Response to Planning application from Hertfordshire County Council (T and CP GDP Order 2015)

District ref: S6/2015/1342/PP
HCC ref: WH/168/2015
HCC received: 7 July 2021
Area manager: Matthew Armstrong
Case officer: Matthew Armstrong

King George V Playing Fields Northaw Road East Welwyn Garden City

Outline Planning Application for residential development of up to 121 dwellings, associated infrastructure and a change of use from agricultural land to an extension of the King George V playing field

DRAWING NUMBER:	141386/A/56	REVISION:	A
-----------------	-------------	-----------	---

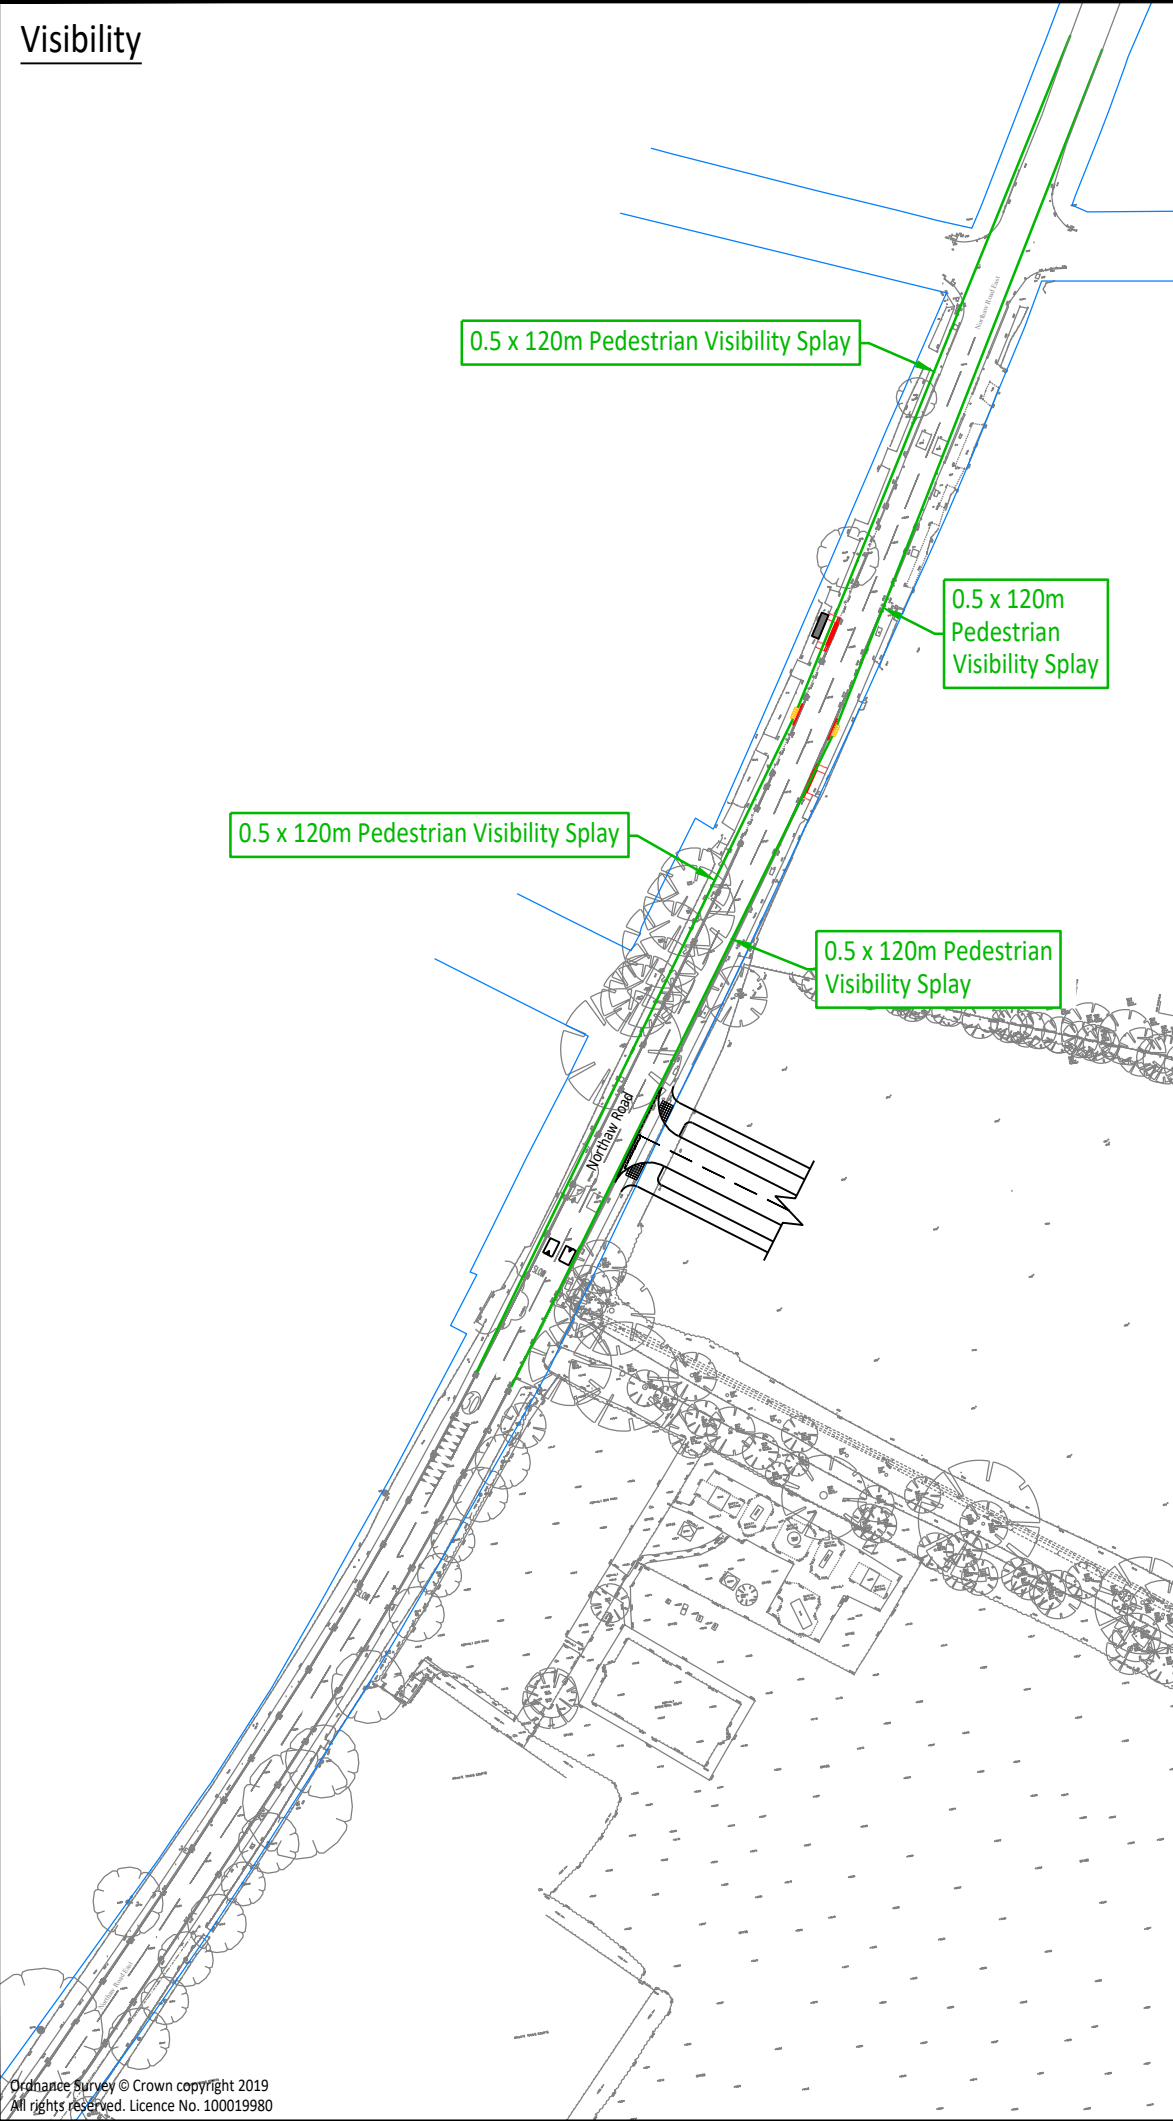
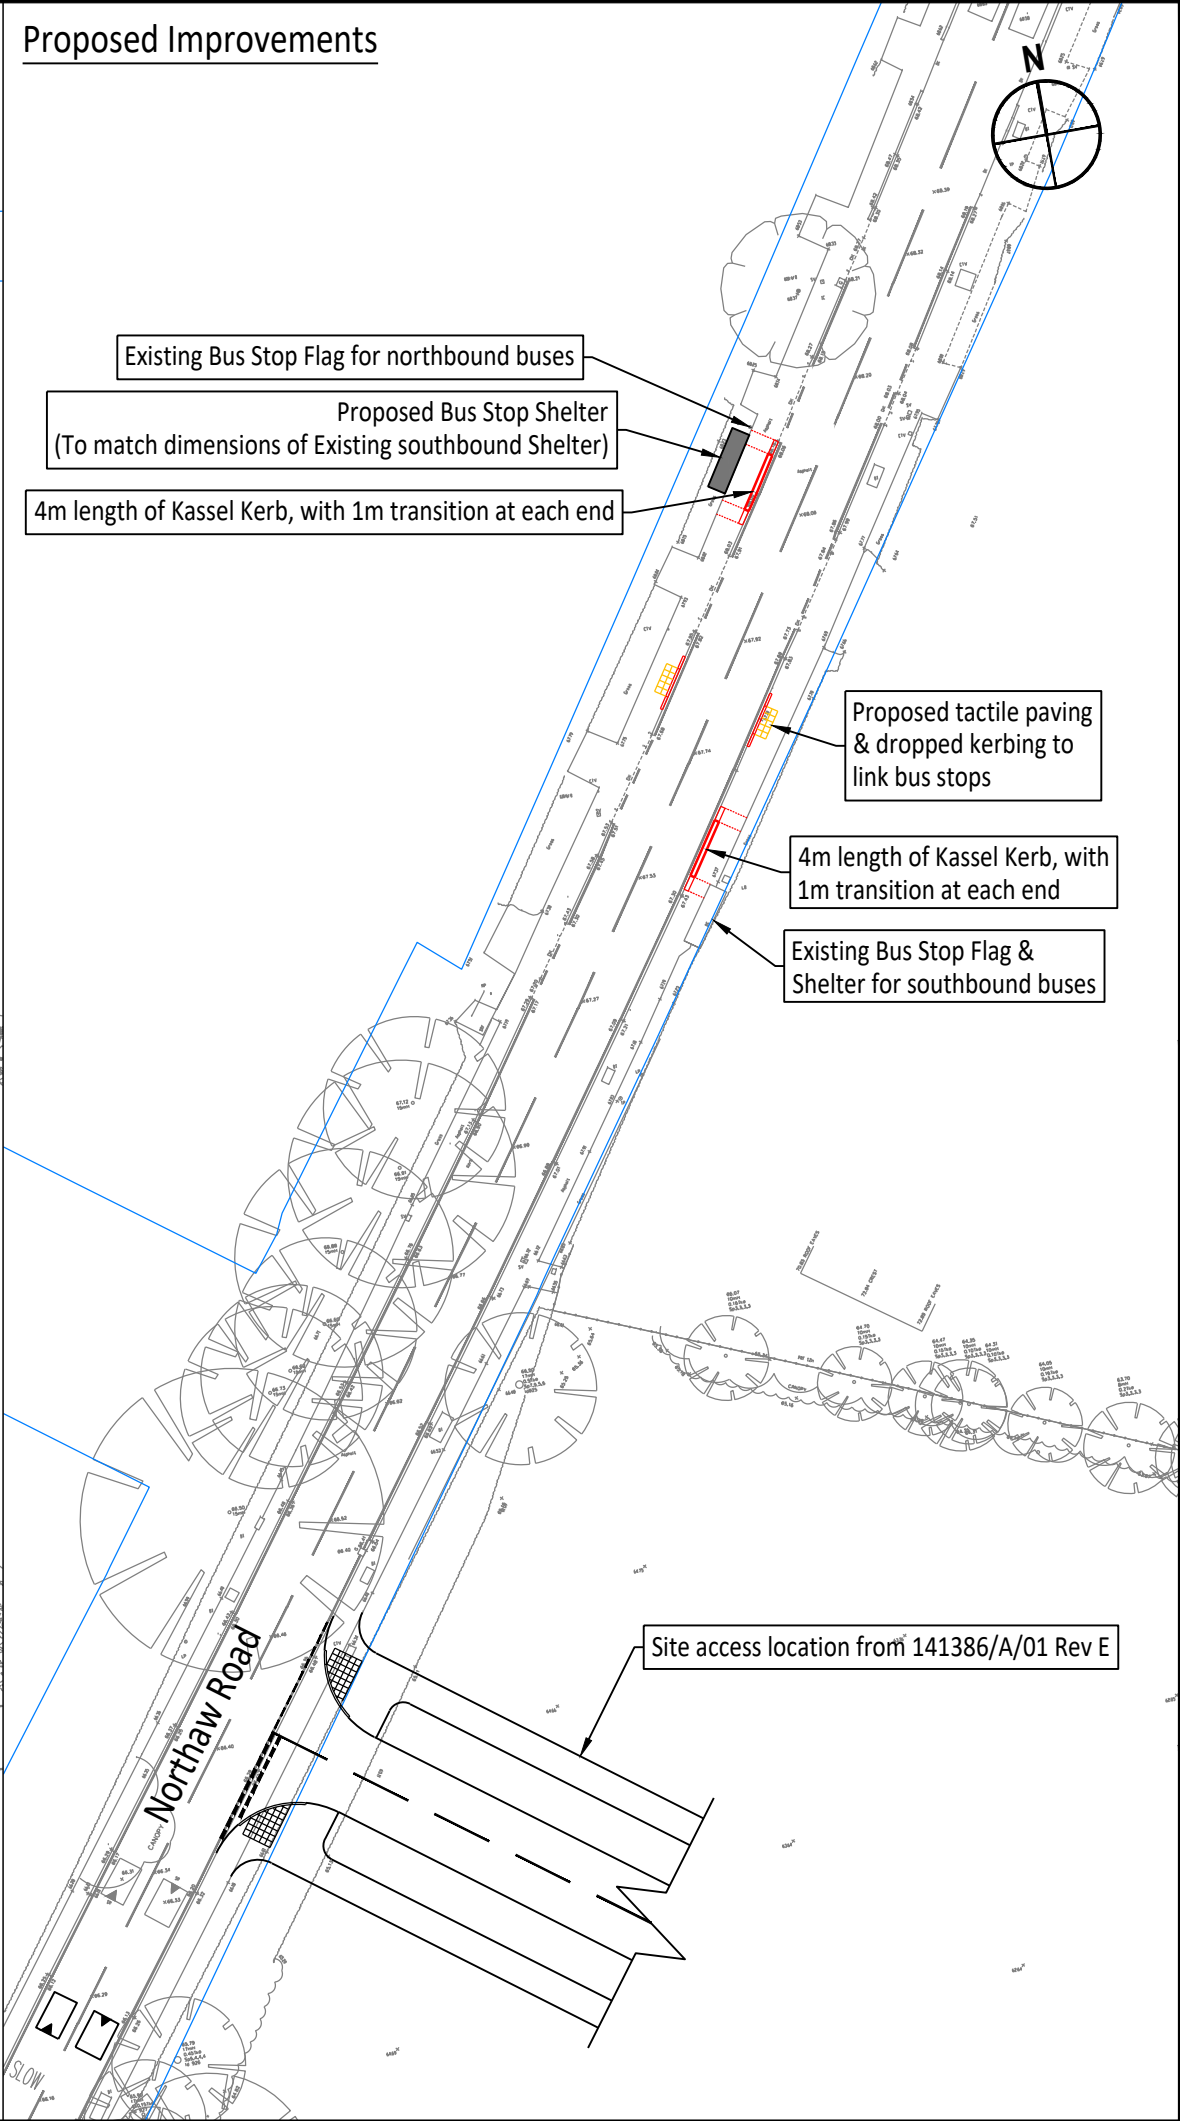
2) Before first occupation of the development, additional plans must be submitted to and approved in writing by the Local Planning Authority, in consultation with the Highway Authority, which show the detailed engineering designs and construction of the highway improvement works to Northaw Road East, as shown indicatively on drawing number 141386/A/56 revision A. This includes:

- Upgrade of the two existing bus stops closest to the site, to include raised Kassel kerbing and Real Time Information displays at both stops, and a shelter at the northbound stop.
- A pedestrian dropped kerb / tactile paved crossing point along Northaw Road East between the two bus stops.

These works shall be constructed to the specification of the Highway Authority and Local Planning Authority's satisfaction, and completed before first occupation.
